BTC response to the Highways England's response to RHS document Appendix 3 [REP8-045] - Letter from Barrell Tree Consultancy to Royal Horticulture Society [REP7-042]

HE comments	BTC response
3.1.1 Highways England (HE) has considered the letter dated 17 April 2020 from Barrell Tree Consultancy to the RHS submitted by RHS at Deadline 7 [REP7-042].

Project Title	M25 Junction 10 / A3 Wisley Interchange Improvement
Drawing Title	ARBORICULTURAL AND TREE PROTECTION SHEET 07 OF 31
Drawing Number	HE551522 - BBA - ELS - WHL_AL_SCHME - DR - LL 000057-B
Original Size	A1
Scale	1:1000
Project Ref. No.	5195939
Sheet	7 of 31
Rev.	P01

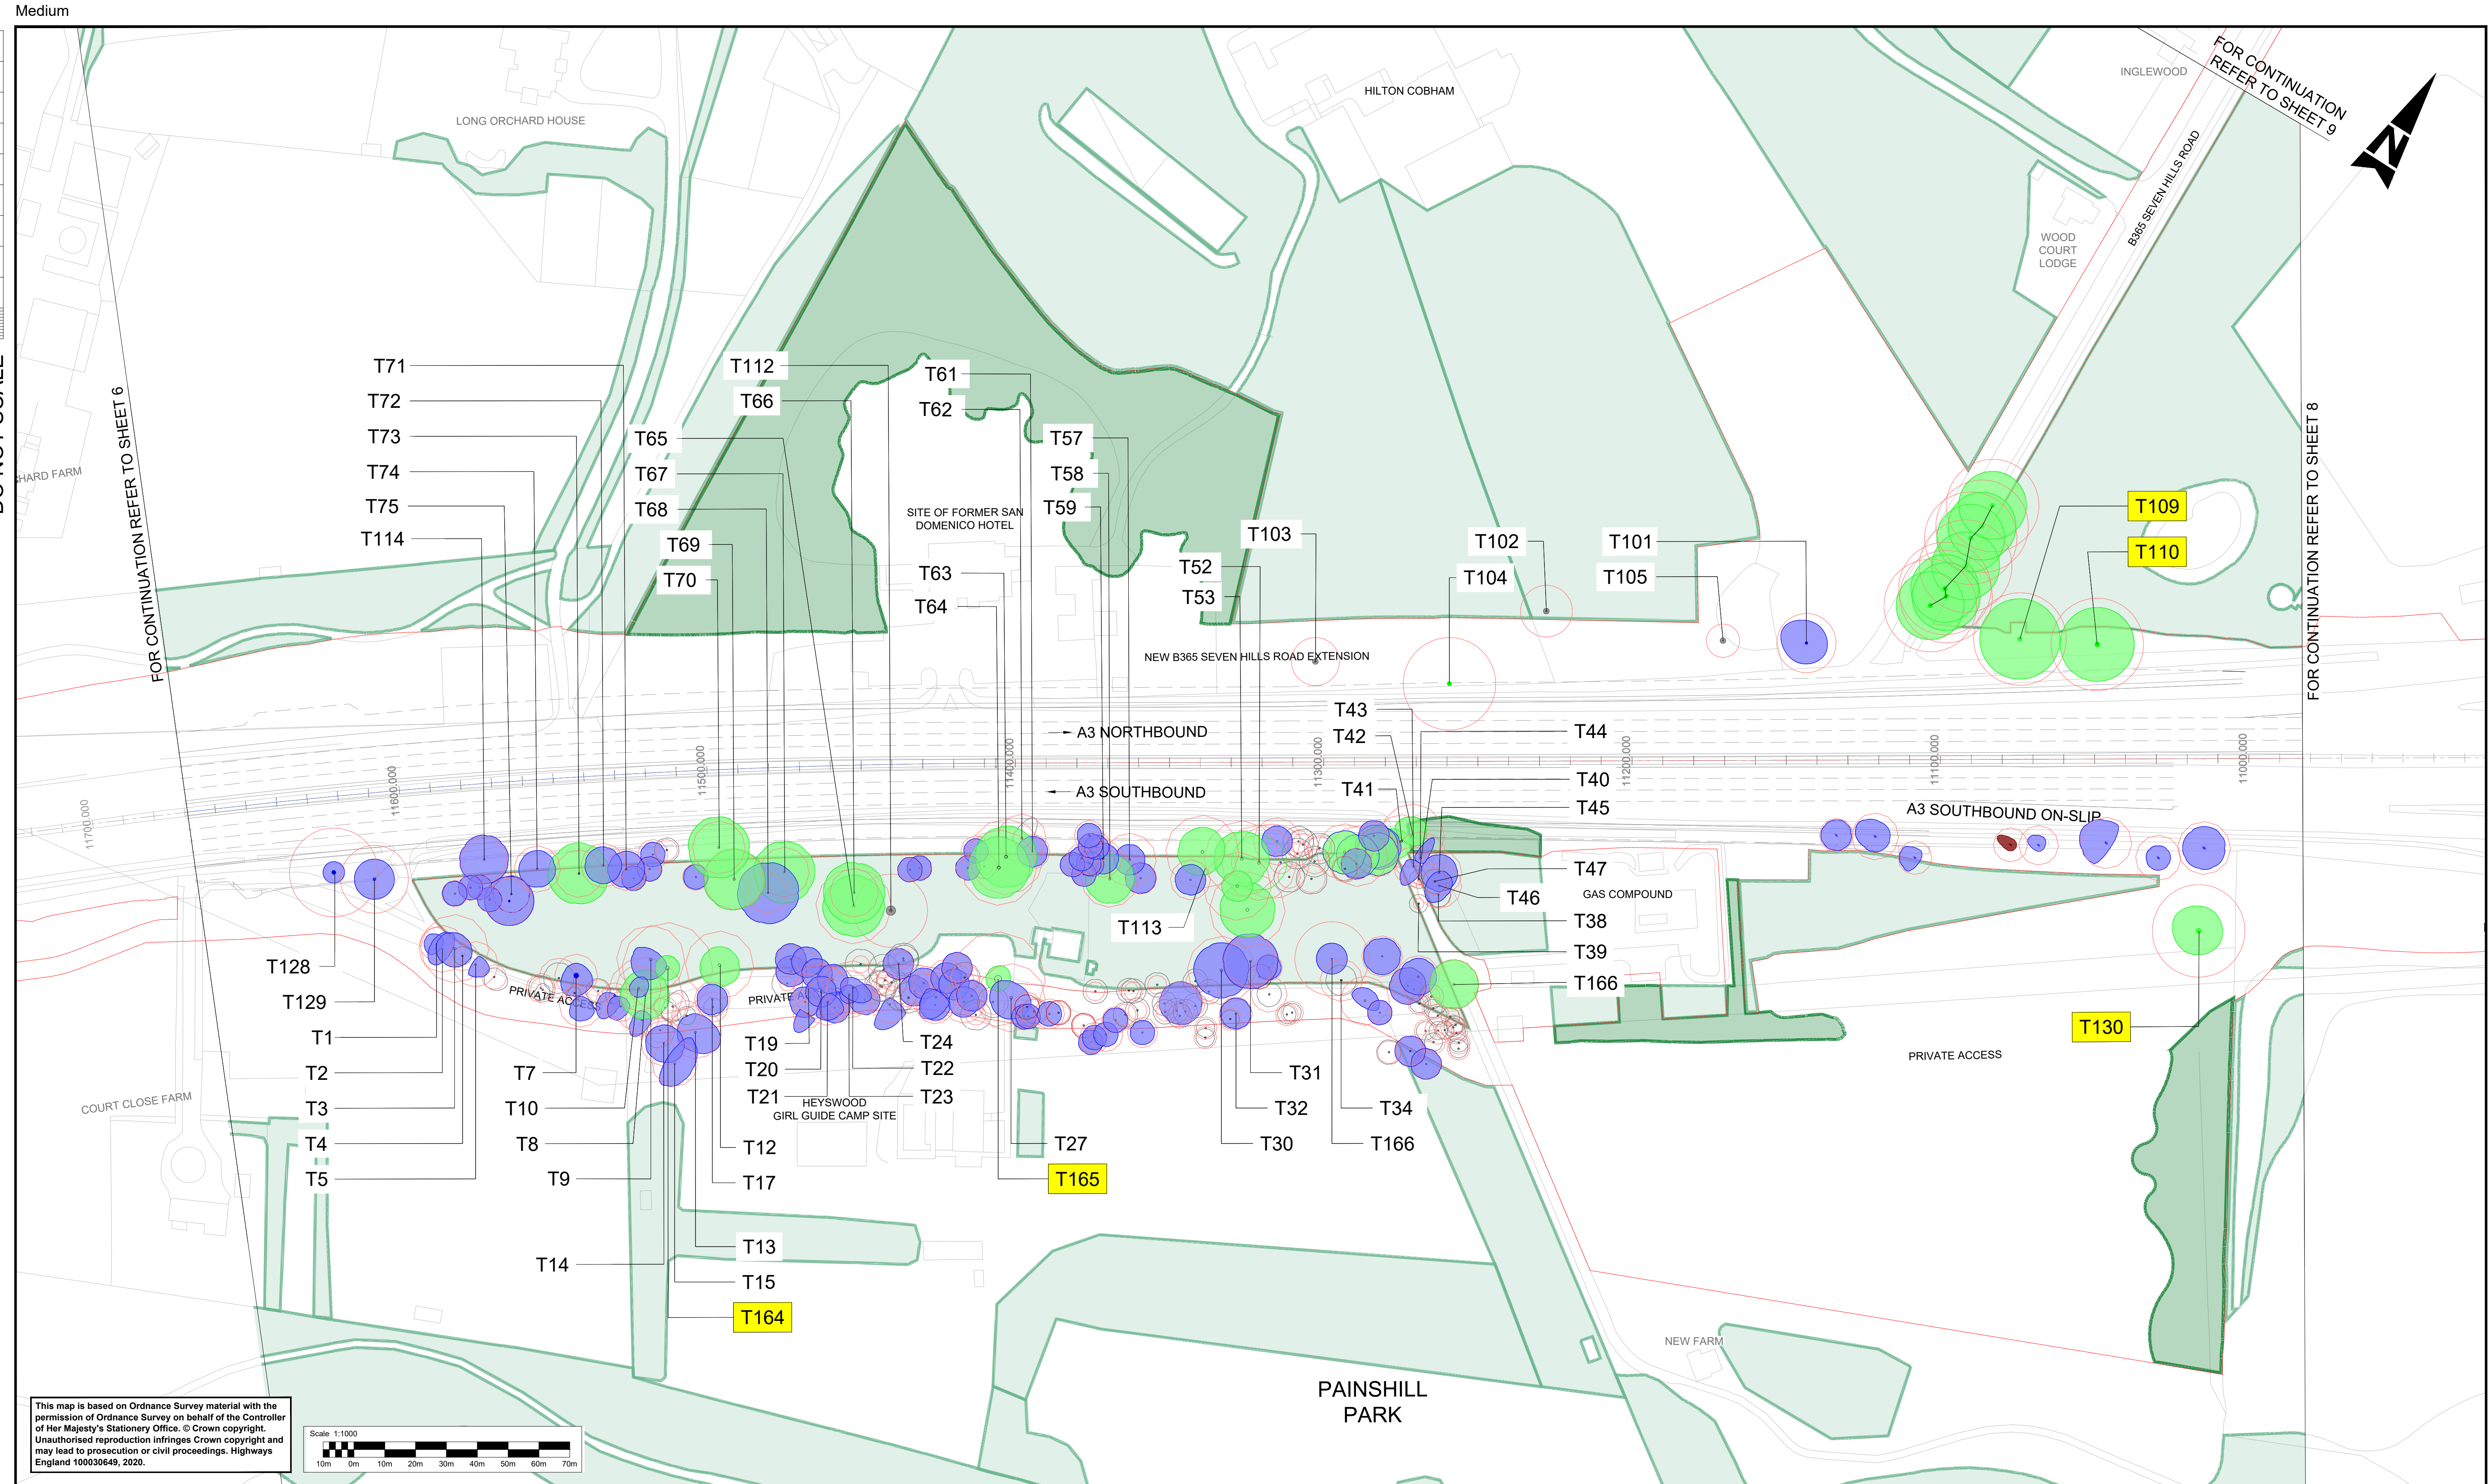
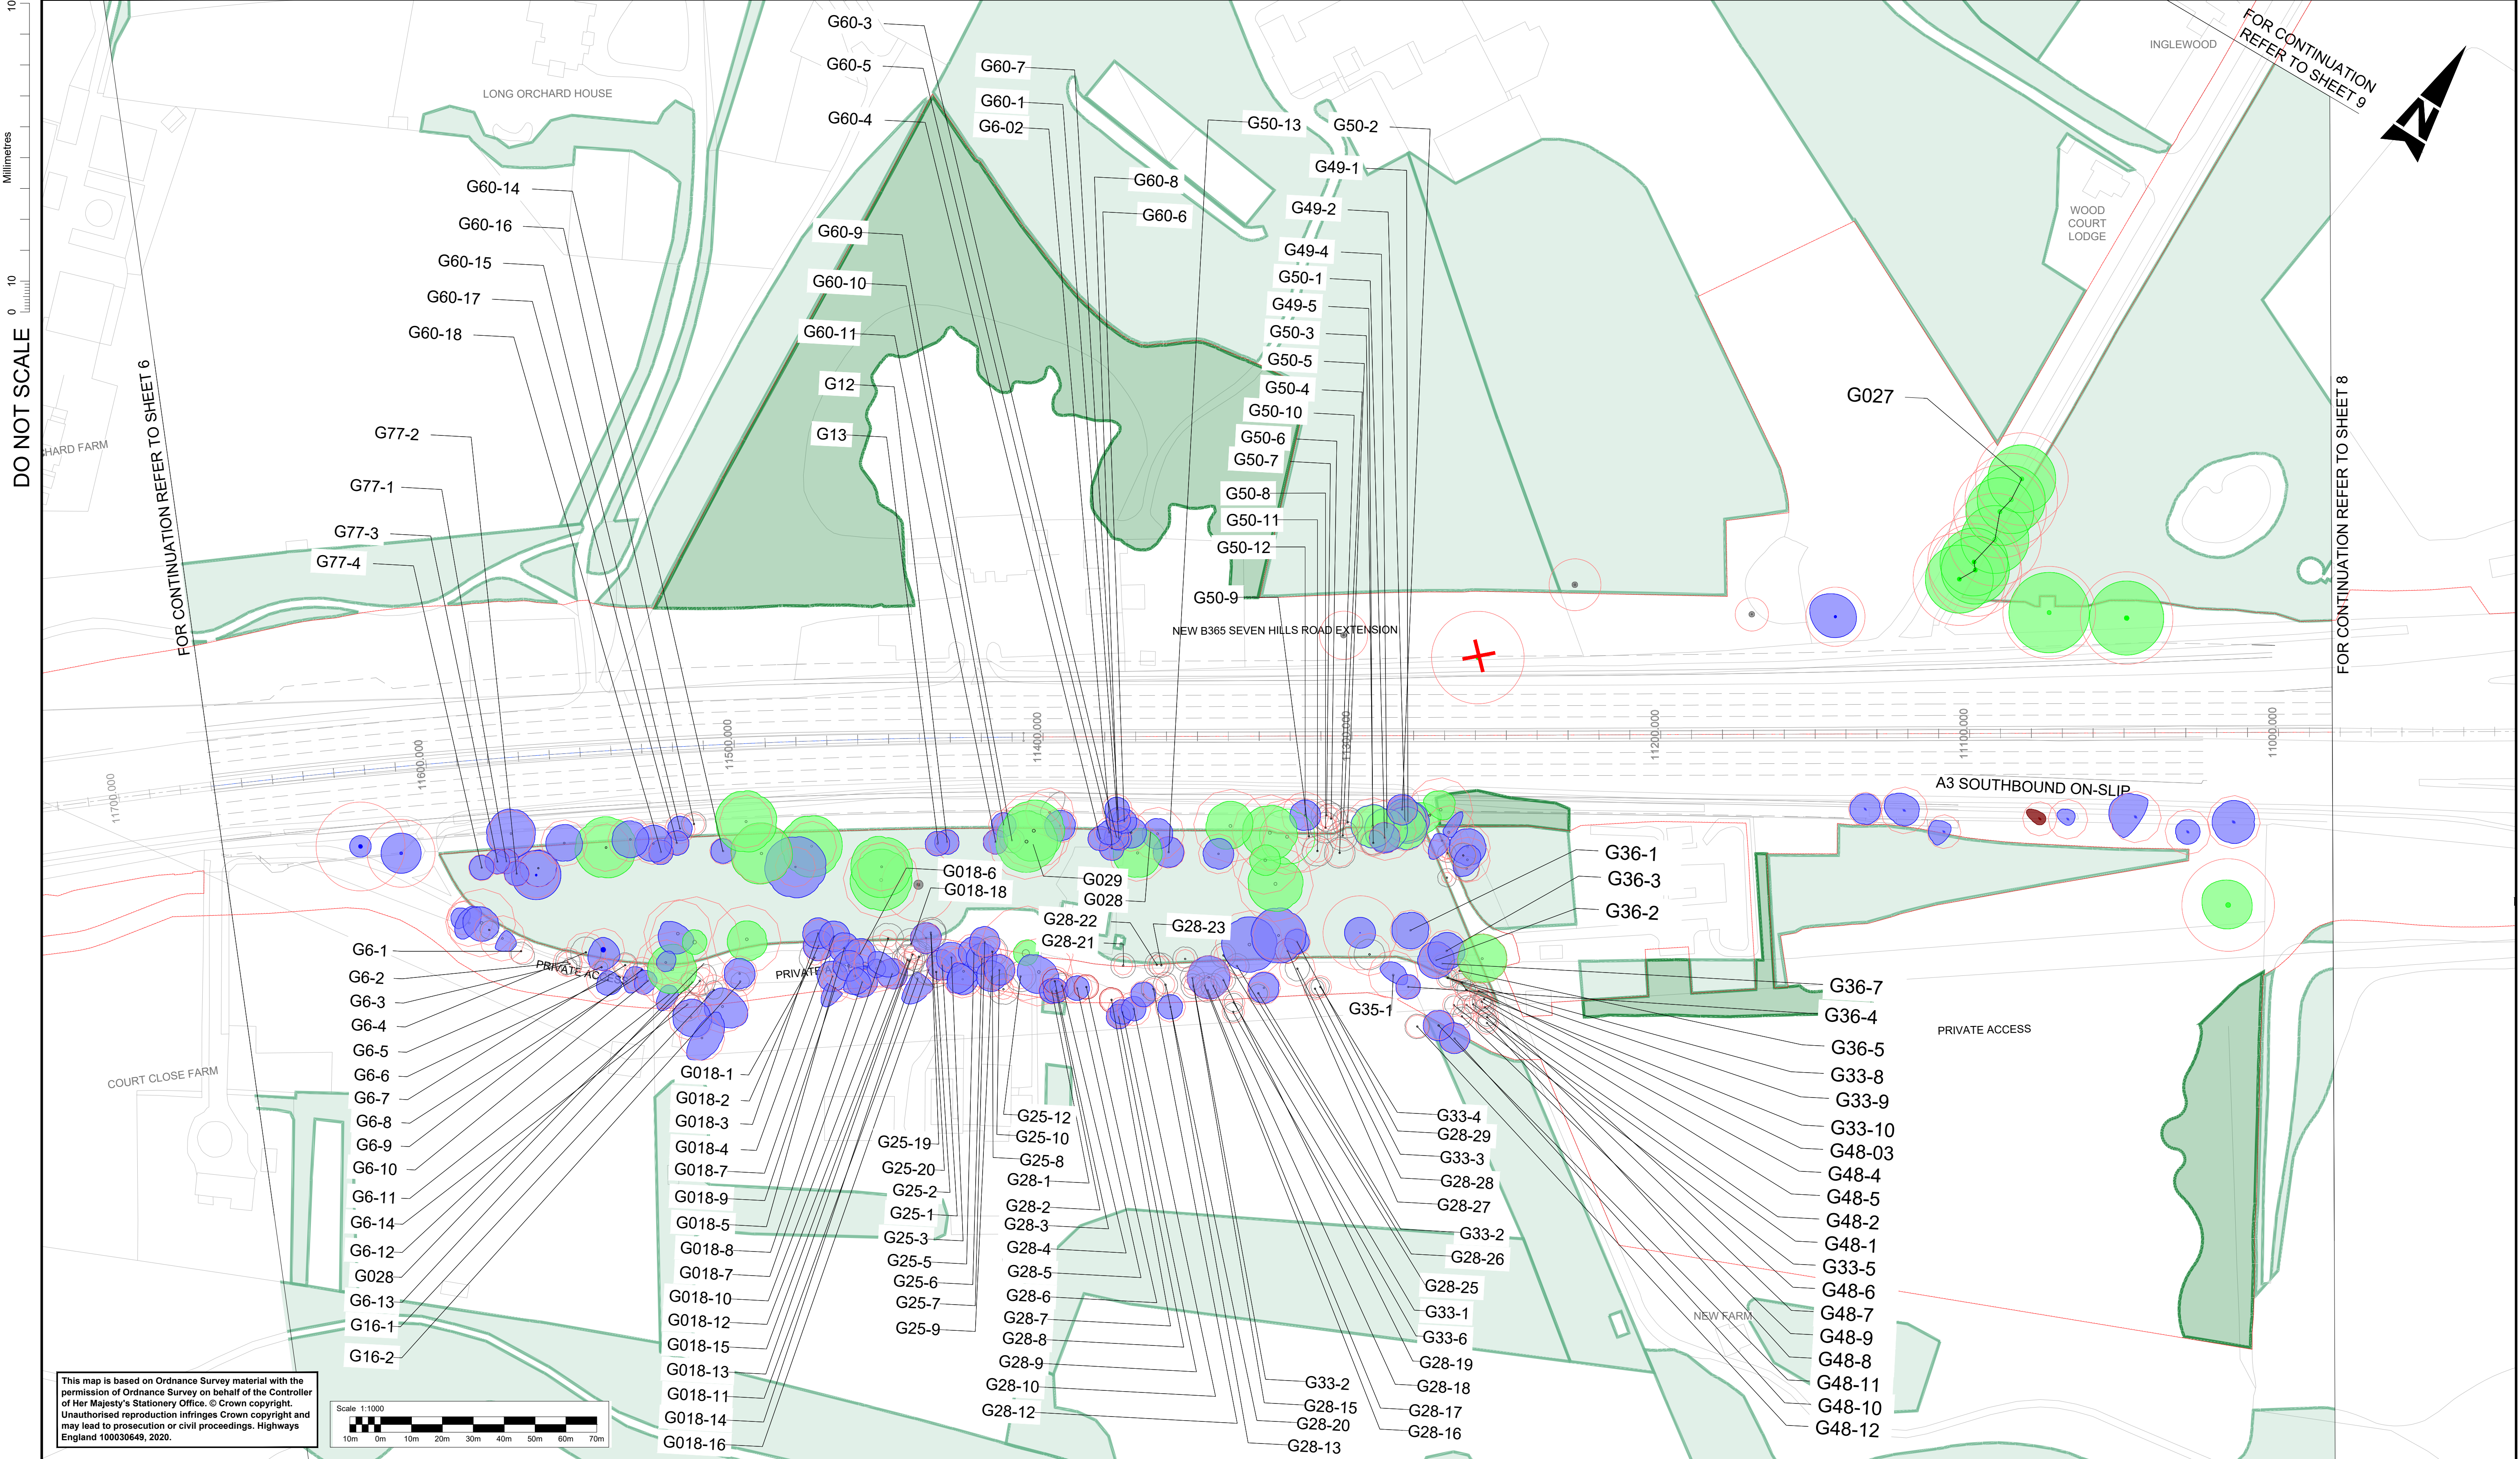
<p>3.1.17 The protection measures for these trees are to be detailed within an arboricultural method statement (AMS) required as part of the CEMP required to be approved under Requirement 3 of the Draft DCO. This will include updating the tree protection plan to show the locations of any protective barriers or ground protection. The AMS will also detail the requirements for monitoring and supervision by an arboriculturist. This addresses point 6 & 7 in the letter.</p>	<p>I agree that they can be retrospectively prepared, but that can only be on the basis that there is a reasonable prospect that proposed works will not adversely affect the trees, and that has not been credibly presented in any way.</p> <p>At the present time, by the Atkins assessment, and my review, at least five of the seven important trees identified cannot be retained without serious adverse impact on their health and prospects. Although they will not die immediately, they will be de-stabilised to the extent that they will have to be immediately removed for safety</p>

HE comments	BTC response
	<p>reasons as they are within falling distance of the A3 and the public visiting Wisley Gardens.</p> <p>This is contrary to the thrust of the HE assessment shown in the schedule and plan of Appendix 7.3, that identify these trees as being for potential removal, when there is no realistic prospect that they can be retained if the works are implemented as shown.</p>
<p>3.1.18 Mr Barrell’s conclusion that the analysis undertaken by Highways England is not credible or fit for purpose is wrong and has been formed without his reviewing all available documentation or requesting any further information.</p>	<p>As confirmed in my <i>Root excavation Report</i>, the data upon which the decisions have been based is seriously flawed because it does not realistically show where important tree roots are located. Contrary to HE’s assertions, my investigations have confirmed that its analysis is not fit for purpose because it has not properly or competently assessed the impact on trees according to the Recommendations set out in BS 5837, i.e. based on the extent of RPAs.</p>
